Subject: 19/01037/REM and 19/00895/REM W of cricket field , N of Wykham Lane

Landscape Planning Officer

Drawing Title **MULTI USE GAMES AREA
 (MUGA)**

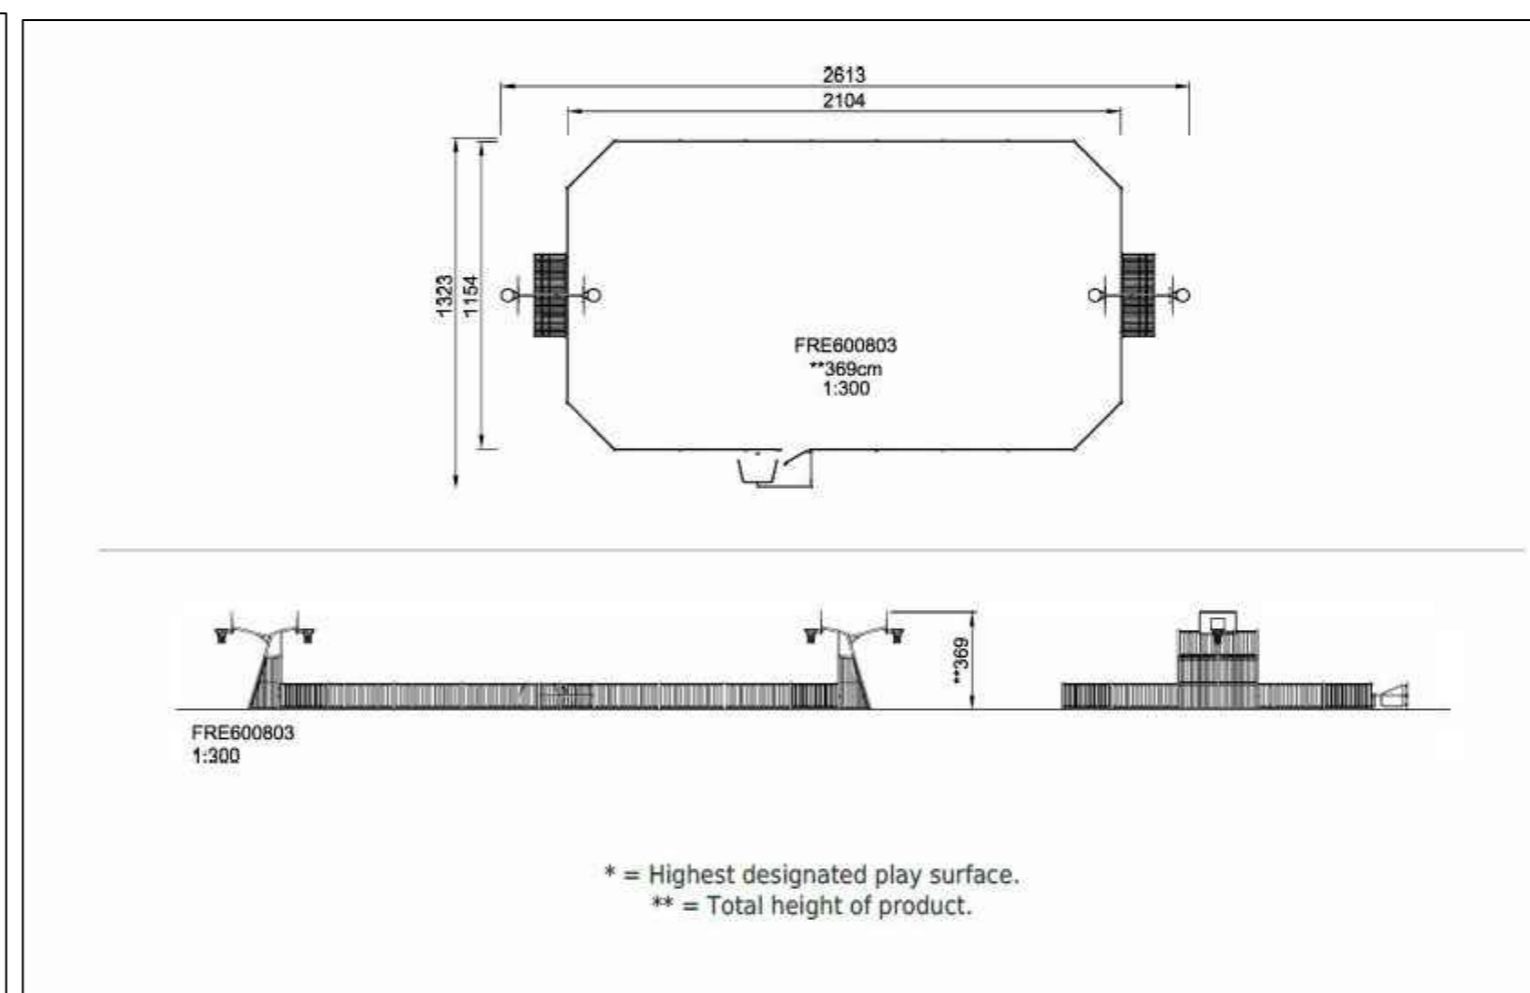
This is located very close to parked cars. It was shown much further away on the framework plan. I think it is too close and risks balls landing on cars .It should be relocated further away from parked cars

The choice of MUGA is inadequate:

It needs to have a 3m high metal mesh fence all round. Not timber effect 1.2m. Visibility into the MUGA is too restricted with slats.

It needs a tarmac surface

Bike racks

A bin with a top and locking litter compartment

Teen seats

Hard surfaced paths to the entrance

The space around need to be designed with planting incorporated

I need to see the MUGA in context with the parking and access points to White Post Road **The MUGA is too close to the car parking. It need access points for maintenance vehicles on the side and a path suitable for vehicles to access it. Gates need to link to footpaths. Need provision for hockey, cricket**

Drawing Title: **Central Play Areas**

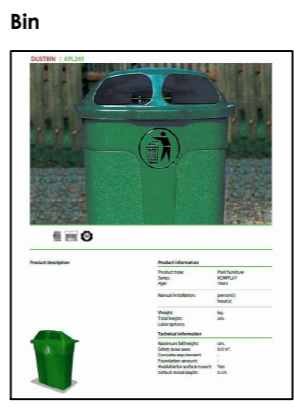
The equipment is poor for the LAP and dire for the LEAP **Equipment needs a total re-think**
The LAP and LEAP need to be within the same fenced area. If you have kids of different ages you can't supervise them between 2 different fenced areas
The adjacent hedgerow trees need to be indicated on the plan. **Needs planting inside fenced area for colour ,texture and scent**
No PCC slabs Seat needs arms
Beech hedge will grow too tall

Don't want the same items as the other LAP so no play house. No springers. A climbing unit and slide would be suitable like item 2

Needs wetpour surfacing

Planting for colour, texture and scent

Seat with arms

No beech hedges

Concentrate equipment together on wetpour

No PCC slabs

This is for older children. The net pyramid is OK the rest is LAP equipment. It needs a couple of swings at least and some challenging items for climbing and balancing

The equipment need to be on wetpour if a heavy use item like a swing and grass reinforcing under others. This needs to be continuous to avoid patches of heavy wear.

Beech hedges are not suitable. They grow too tall and prevent passive supervision into the area

Needs attractive planting

TITLE: **Adoptable Drainage**

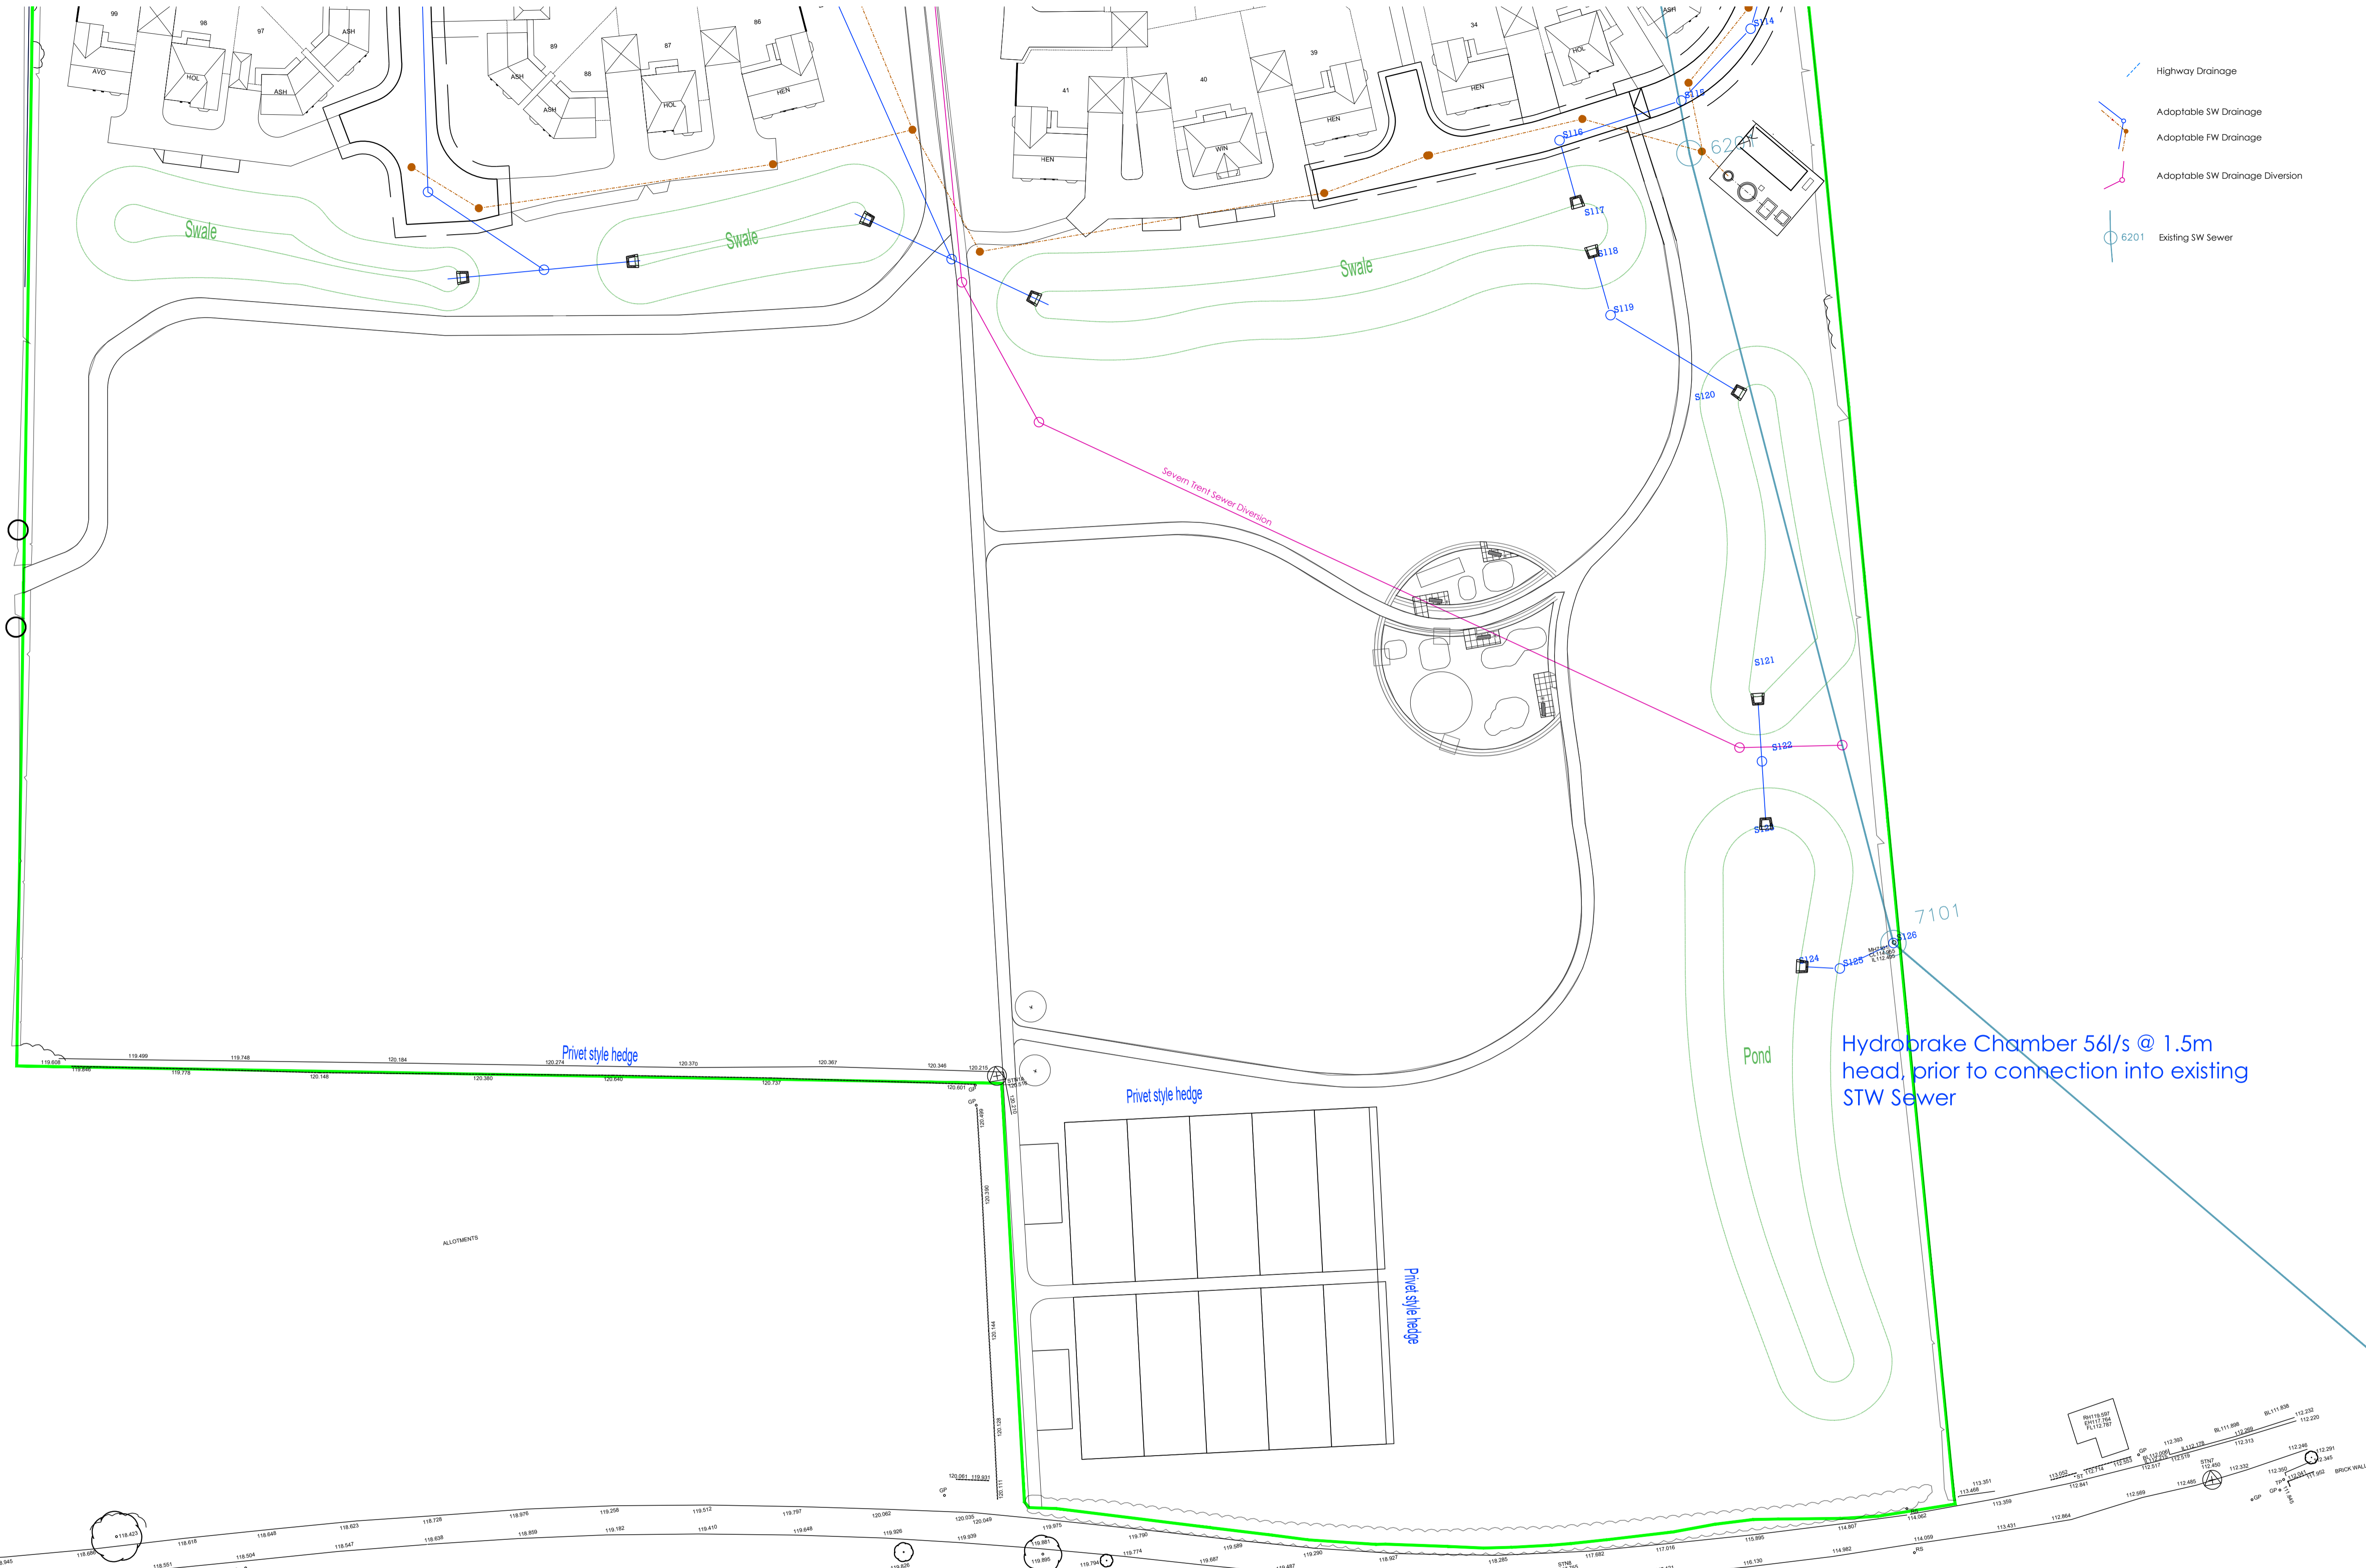
What are the rectangular areas on Adoptable drainage sheet 3?
